PROJECT NAME: UNSW G25 Education Building

SSD-74670005

Subject: Objections Regarding Proposed Development SSD-74670005, 8 High Street, Kensington (Lot 5 DP 1264171)

Figure 71 Extract of proposed plans showing Elevation – South

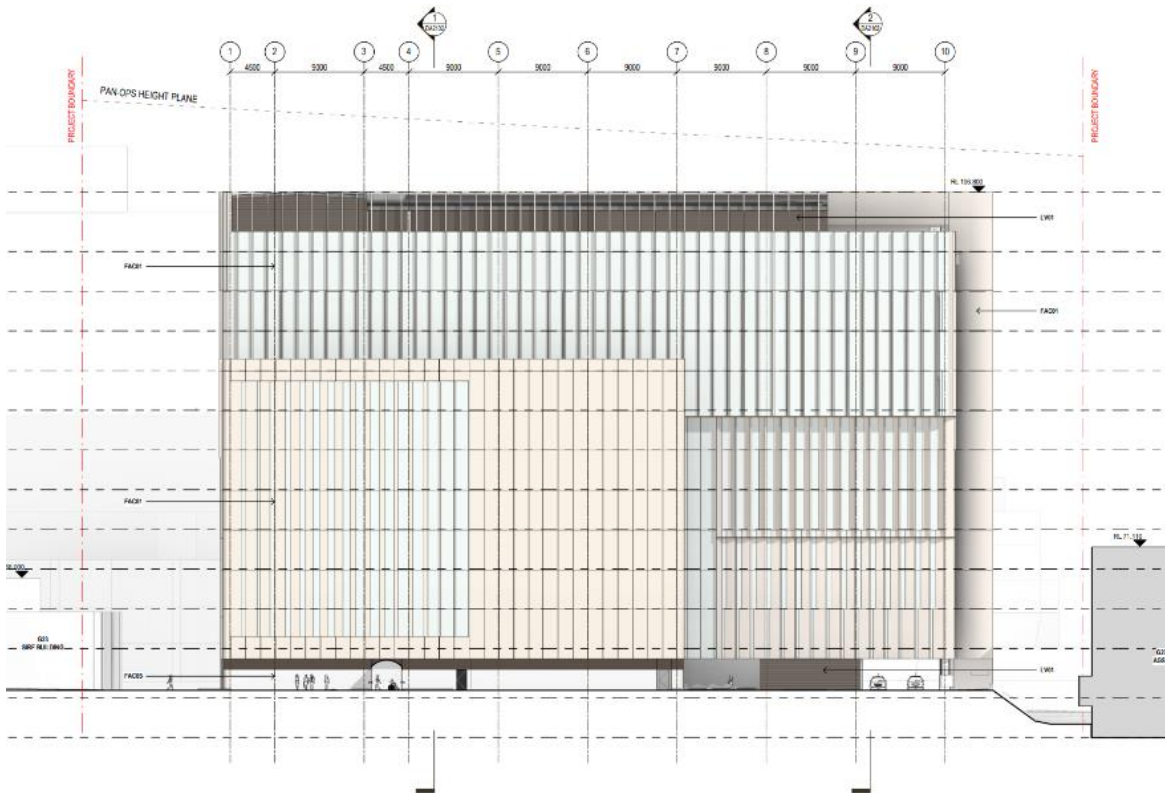
Current plans suggest large south-facing windows from Level 7/8 upwards, which could offer views into our property (14a Norton Street) and other nearby residences. This could lead to our day-to-day activities being visible.

- Consideration of privacy-mitigating window treatments for south-facing windows above Level 7.
- A discussion with planners regarding designs that overlook residential properties, or alternatively, a review of the proposed height to lessen these privacy concerns.
